Ref: SSD-79146716

RE: SUBMISSION TO SSD-79146716 - FOR PYMBLE LADIES' COLLEGE SECONDARY INNOVATION PRECINCT AT 20 AVON ROAD, PYMBLE

Ku-ring-gai Council's objection to SSD-79146716 - 20 Avon Road, Pymble (Pymble Ladies' College Secondary Innovation Precinct)

SITE PLAN - PROPOSED

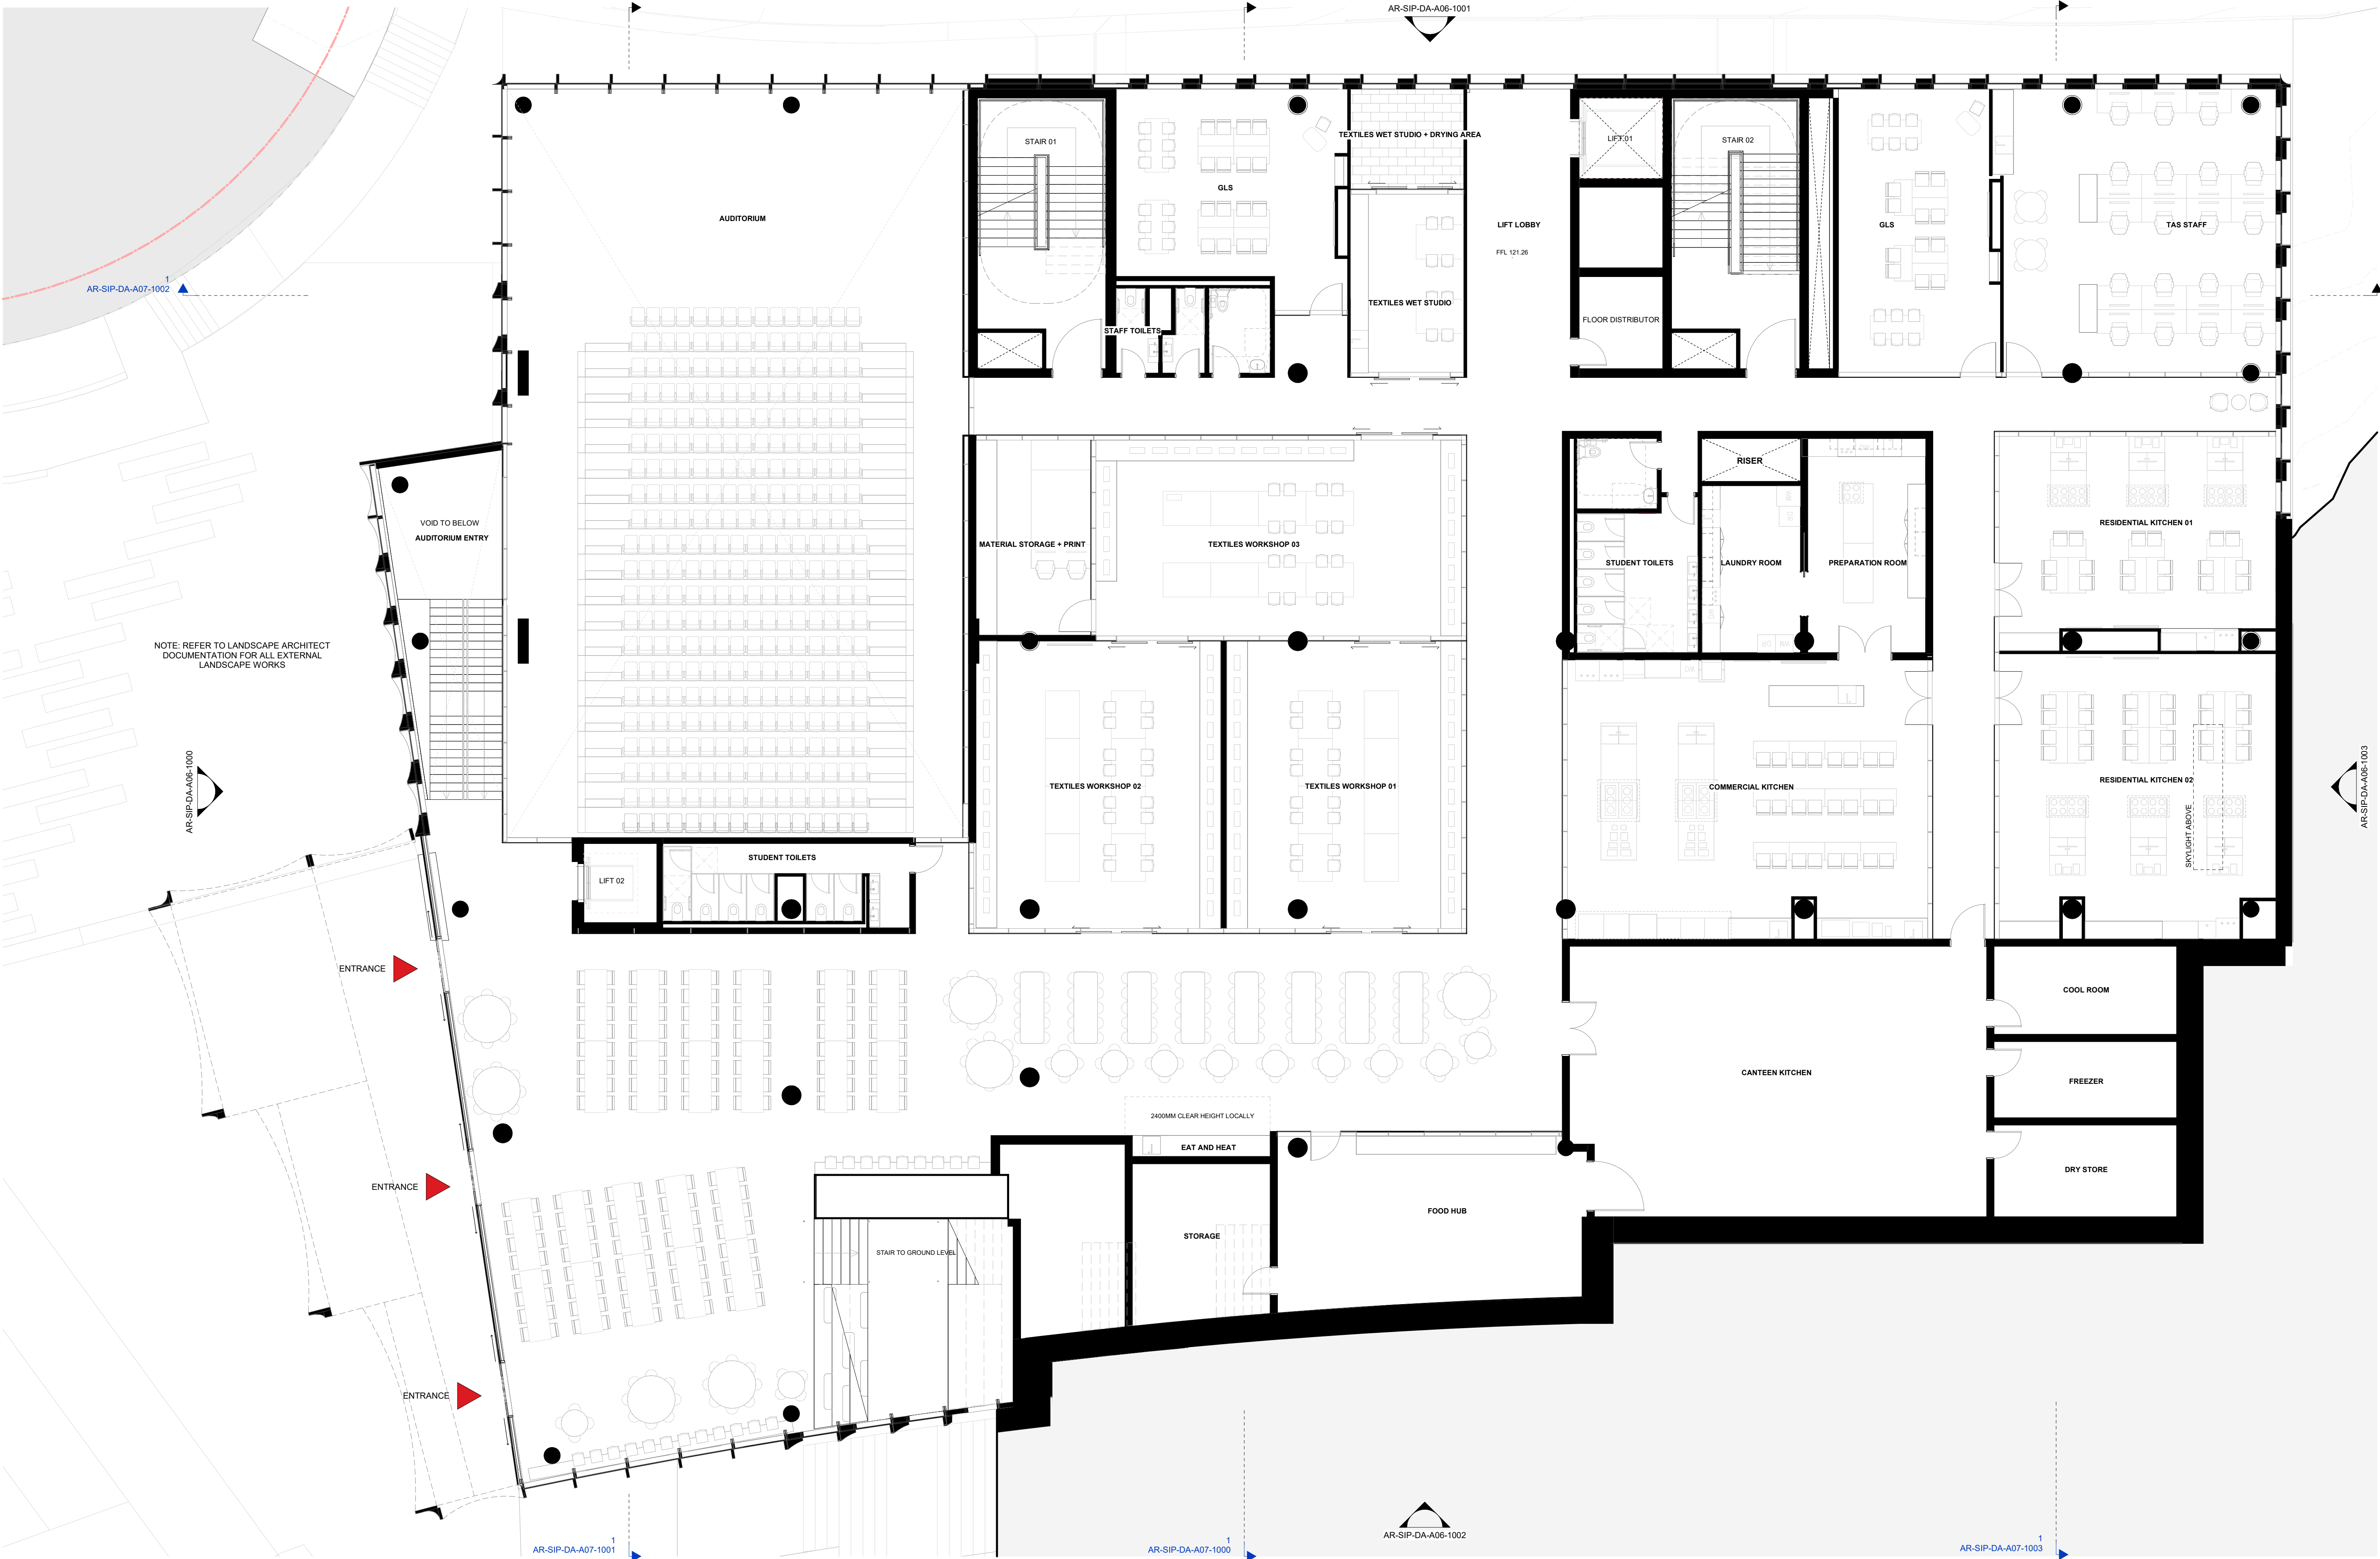
However, this conclusion appears to rely on the assumption that all existing vegetation between the proposed development and Avon Road will be retained. In practice, a number of trees in this area are proposed for removal, including several large specimens identified as having 'High Retention Value' (refer to **Figure 2**). It is also noted that the area where tree removal is proposed sits at a higher ground level, which then slopes downward toward the site boundary (refer to **Figure 3 and 4**)—potentially increasing the visual exposure of the development.

DRAWING
ELEVATION - NORTH
DRAWING NUMBER
AR-SIP-DA-A06-1001
ISSUE
4

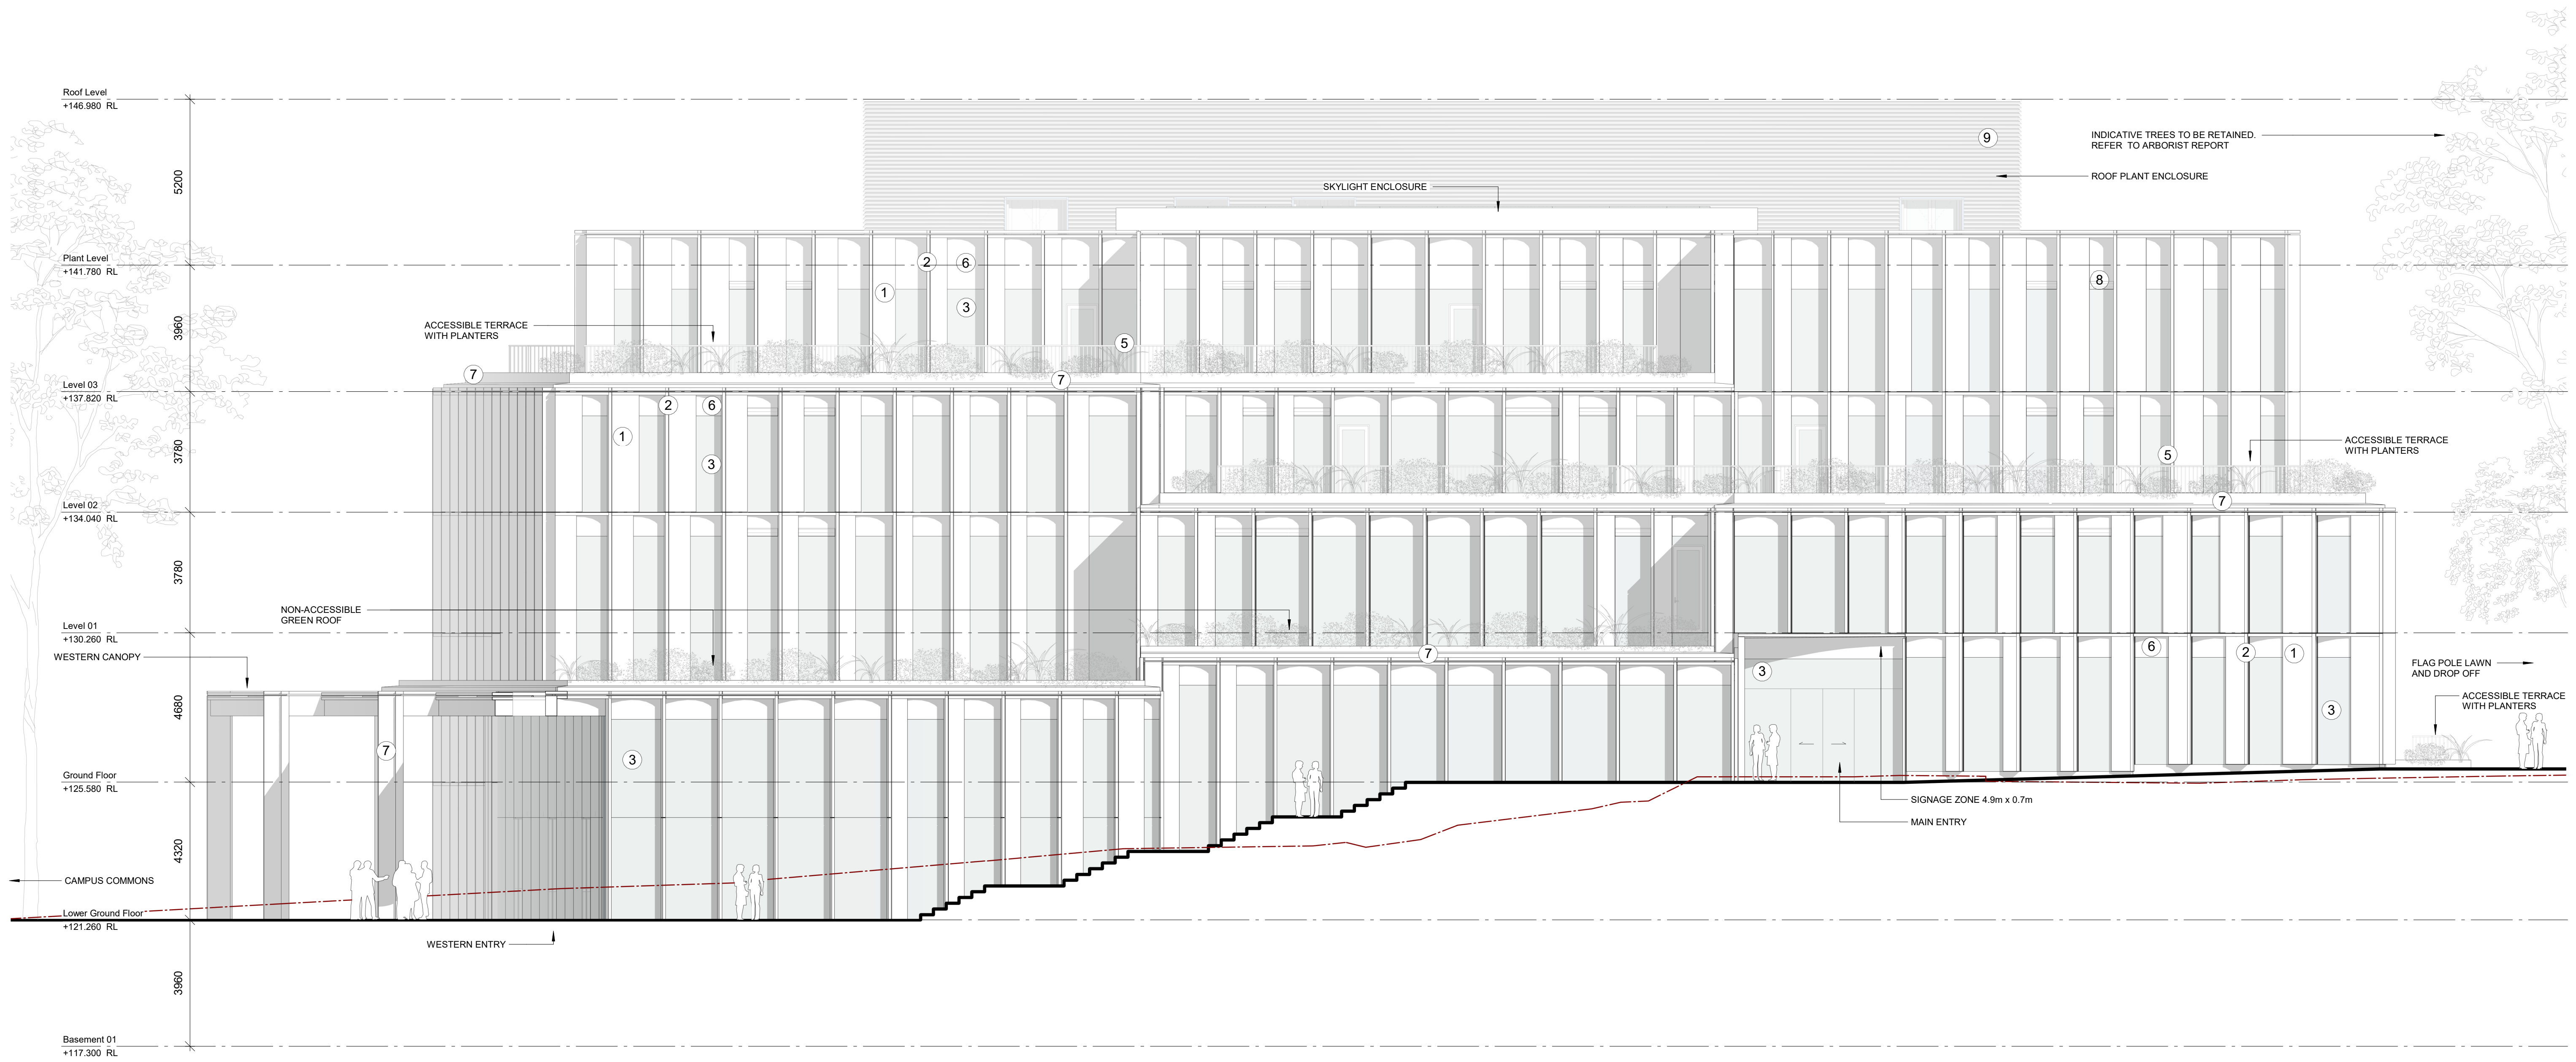
The proposed northern façade, which fronts Avon Road, comprises six storeys with an additional roof plant enclosure, resulting in a total building height of 29.68 metres (refer to **Figure 1a**). This represents a significant change in scale when compared to the adjacent R2-zoned low density residential dwellings along Avon Road. Furthermore, this façade lacks articulation or modulation to reduce its visual bulk. While this contrast in scale may be less of a concern if the building is not visible from Avon Road, this assumption requires careful consideration.

Further to the point above, the proposed roof plant enclosure may be highly visible from neighbouring low-density residential dwellings, particularly given its location directly adjacent to the northern boundary with no setback to reduce its visual prominence. The absence of a setback contributes to the perceived bulk and scale of the structure when viewed from Avon Road and surrounding properties (refer to Figure 3 and 4).

There is limited information provided regarding the design character and materiality of the enclosure. The Architectural Plans indicate the use of 'Solid Aluminium Louvre Panels – Colour: Dark Grey'. Depending on the final finish and detailing, this material could appear visually dominant within the surrounding residential context, particularly if viewed against a backdrop of lighter vegetation or sky.

It is recommended that consideration be given to introducing a setback from the northern boundary to reduce the visual impact of the plant enclosure. In addition, further design refinement is encouraged, including careful consideration of the enclosure's materiality, colour, and detailing, to ensure it does not present as a visually obtrusive element within the streetscape or from neighbouring properties.
